Subject: RE: Y/101/19/DOC - Yapton View (land off Burndell Road), Yapton, BN18 0HW

In relation to the above application, I understand from the submitted documents that Geo-Environmental's Remediation Strategy and Verification Report (ref.: GE18533/RSVR/SEP19, dated September 2019) has been provided with the aim of allowing discharge of condition 3 (remediation strategy) and condition 5 (verification plan). In order for this Department to consider discharging the conditions, please may the following points be addressed:

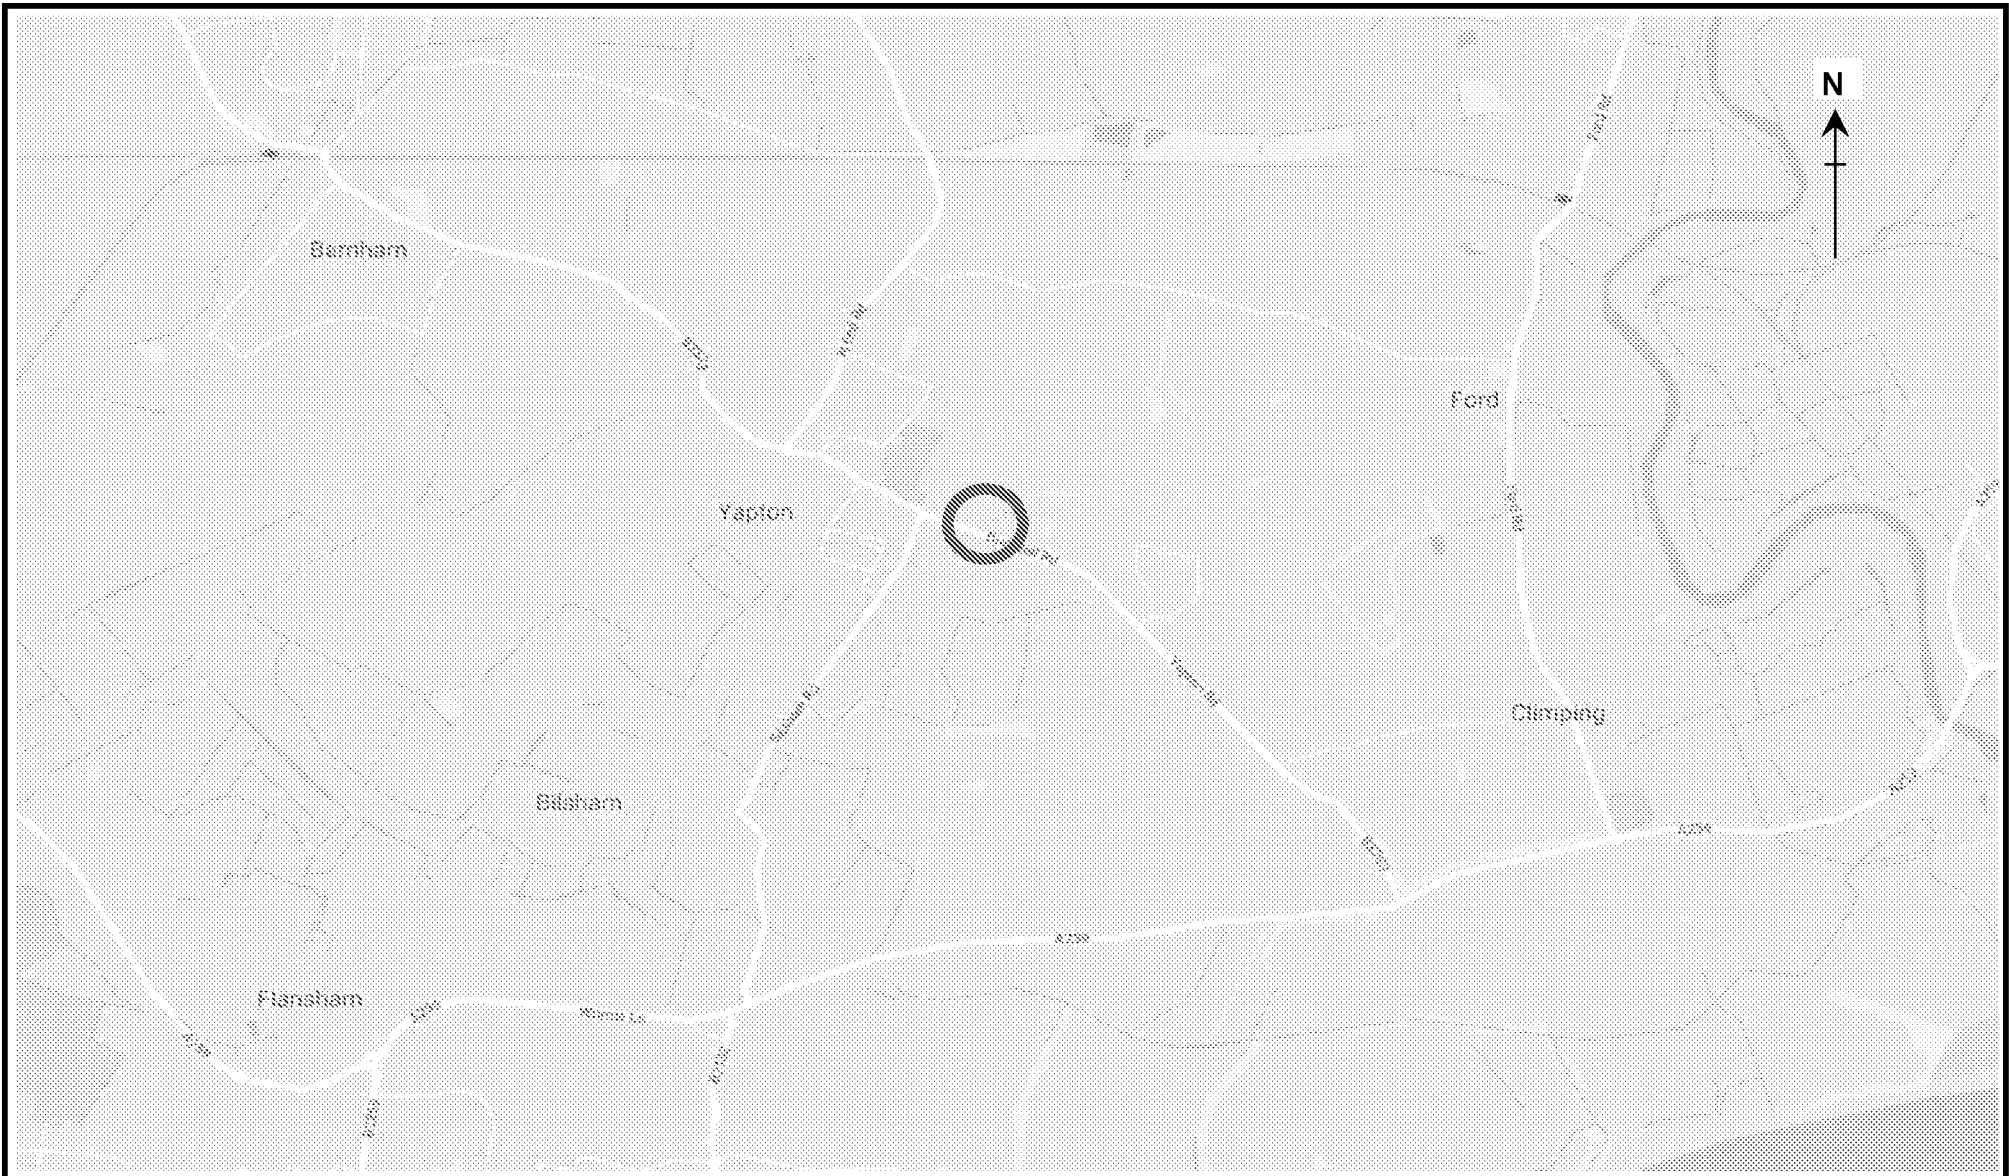
- date(s) of remedial work (it is noted that the visit to confirm the mass excavation was 15 April 2019)
- provision of the post-excavation validation sampling
- evidence of removal of material from site to a suitable facility (hazardous waste)
- evidence of the membrane placement
- evidence of material imported to site
